October 21, 2015

RE: 5637 Mercer Way – Peer review response
SWC Job#14-206

This letter and attached revised Critical areas report and revised Critical Area Enhancement Plan, are in response to the July 29, 2015 ESA peer review letter regarding this project.

CRITICAL AREA ENHANCEMENT PLAN
- MITTREHOUSE LLC -

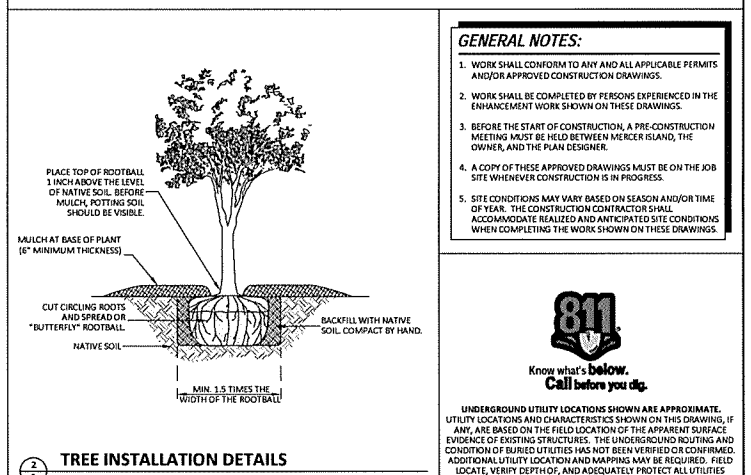
- Temporary wetland and wetland buffer impacts should be identified in the impact assessment and accounted for in the mitigation plan.

- The critical areas enhancement plan figure, Sheet 1 of 1, should indicate the stream flows to the east.

Response: The revised Critical Areas Enhancement Plan identifies areas of temporary impact with associated restoration plantings.

The mitigation plan has been revised to note the stream flows to the east as requested.

A PORTION OF GOVERNMENT LOT 3, OF SECTION 19, TOWNSHIP 24 NORTH, RANGE 5 EAST, W.M., KING COUNTY, WASHINGTON

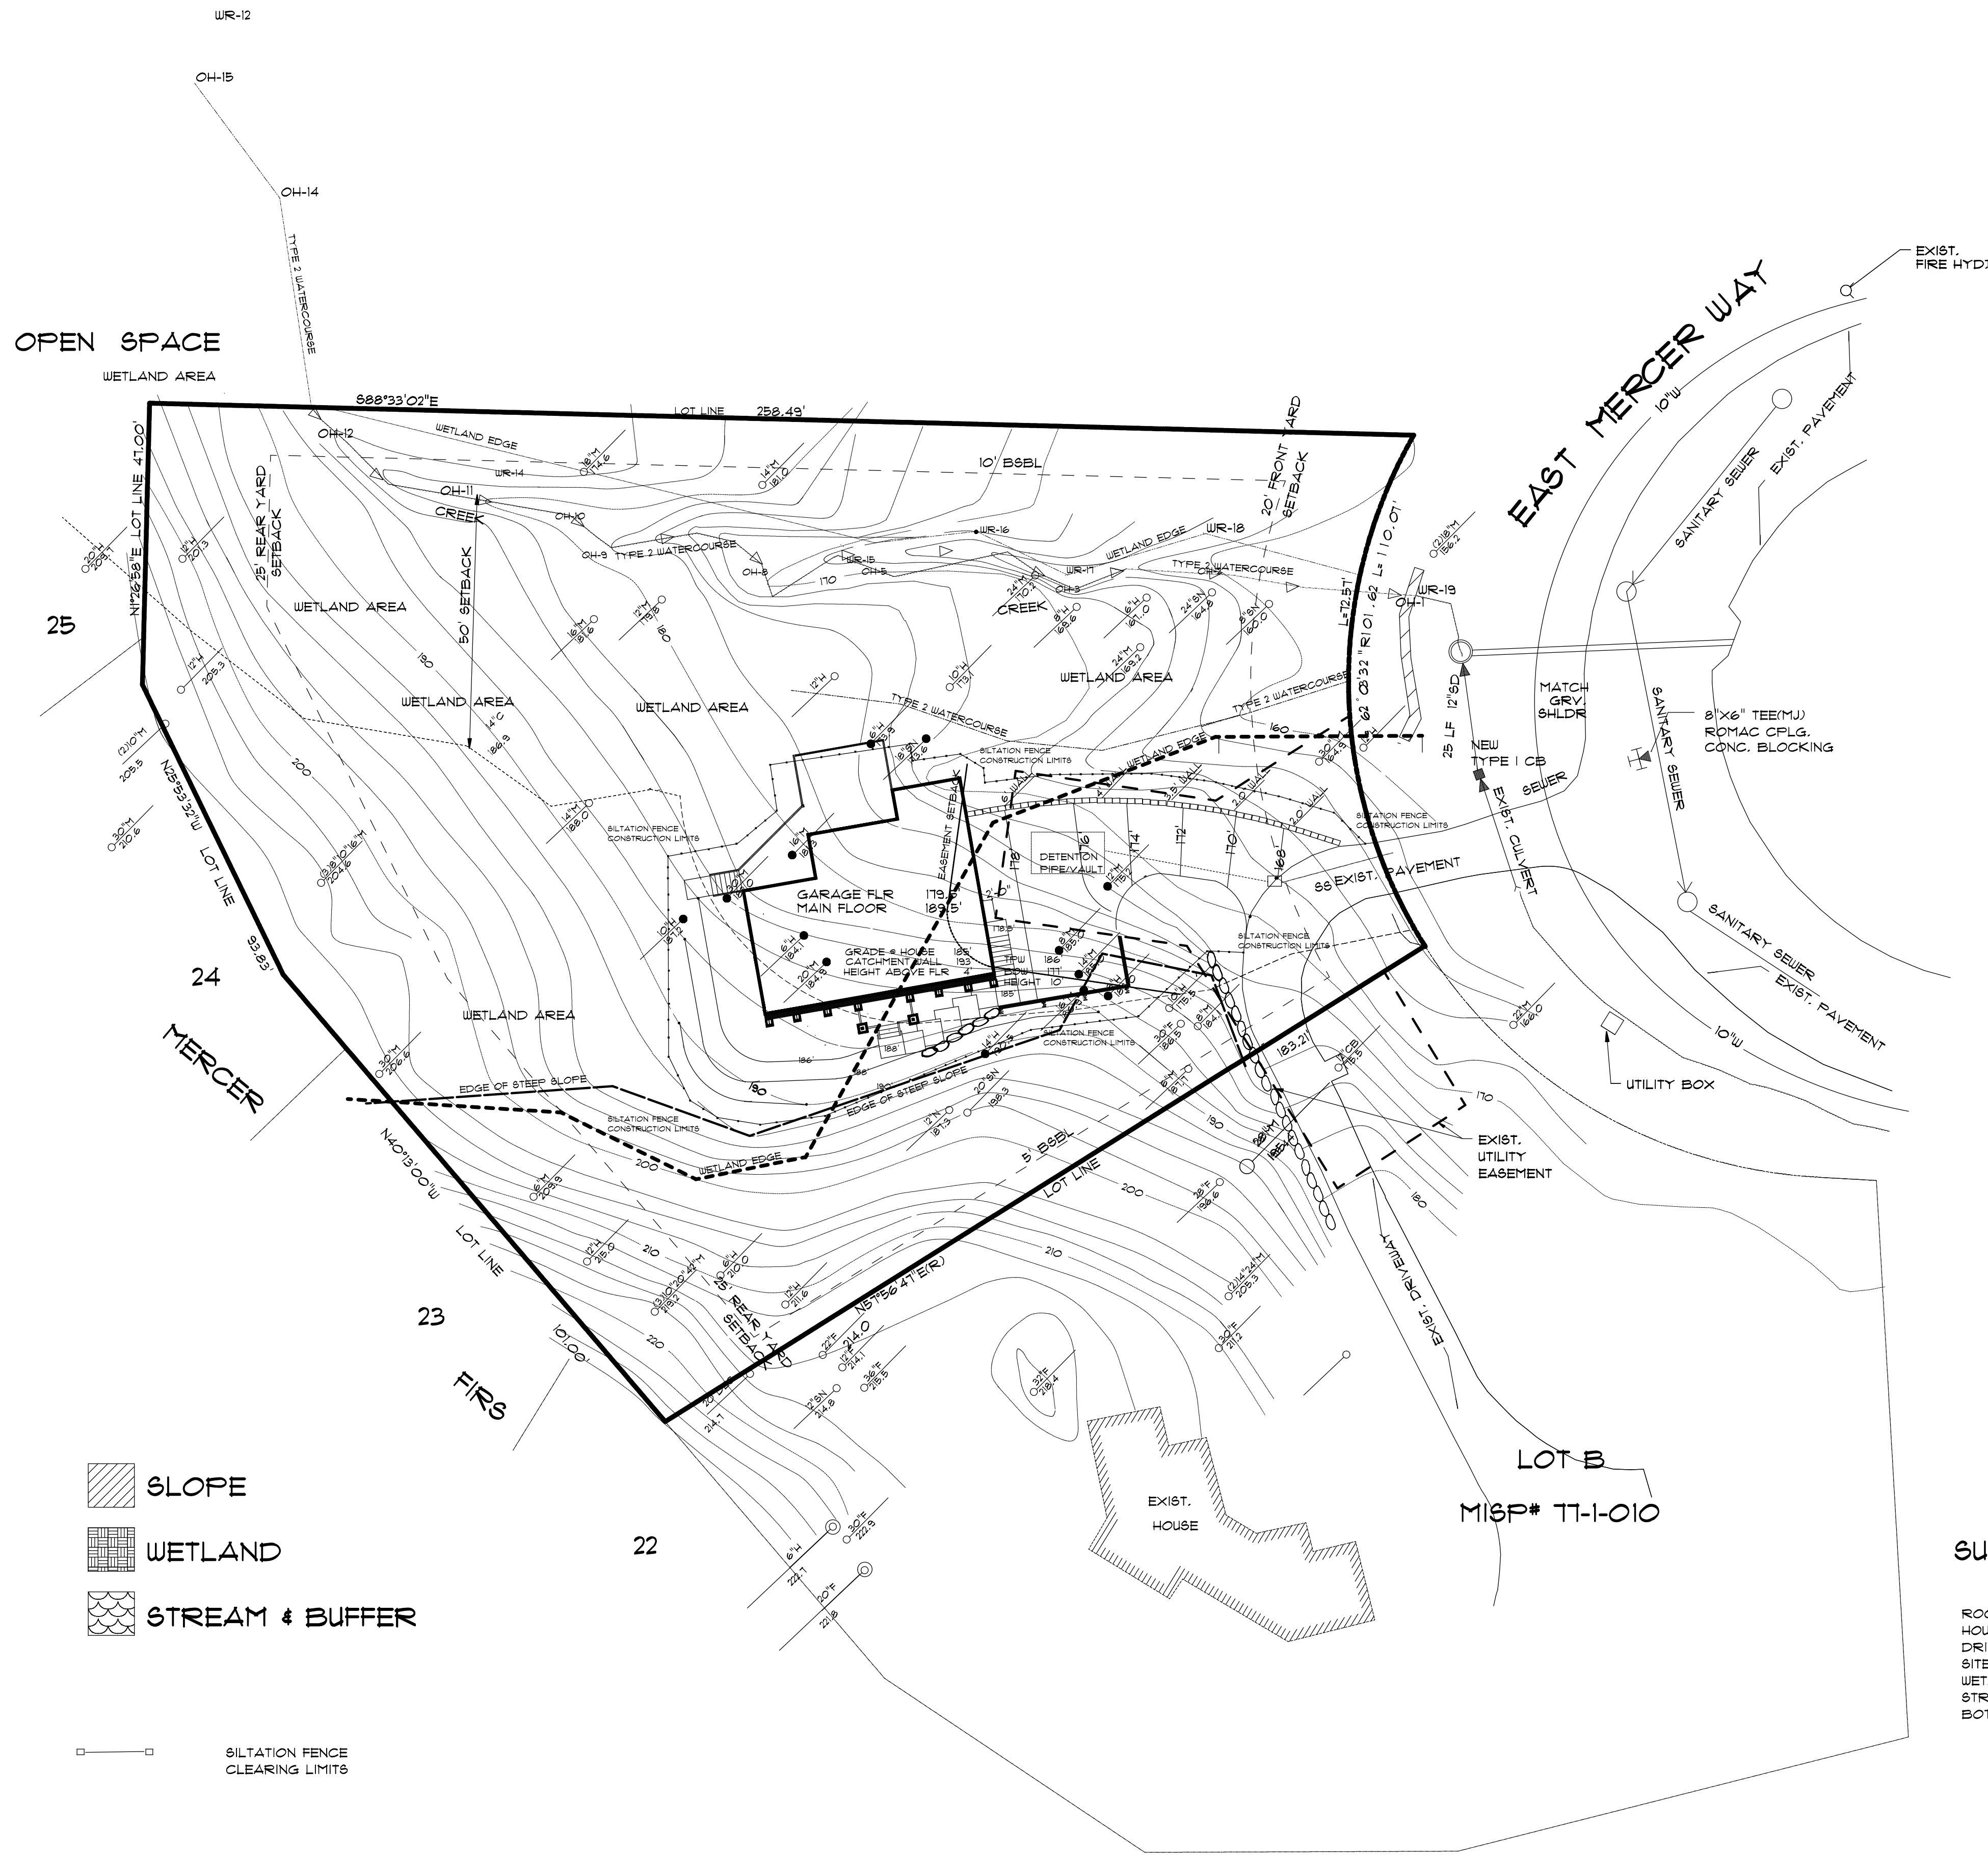
- The newly identified stream should be flagged and surveyed in the field and the stream boundary and associated buffers should be included on appropriate project plans and the mitigation plan.

The second stream identified during the review is now depicted on the site plan as requested.
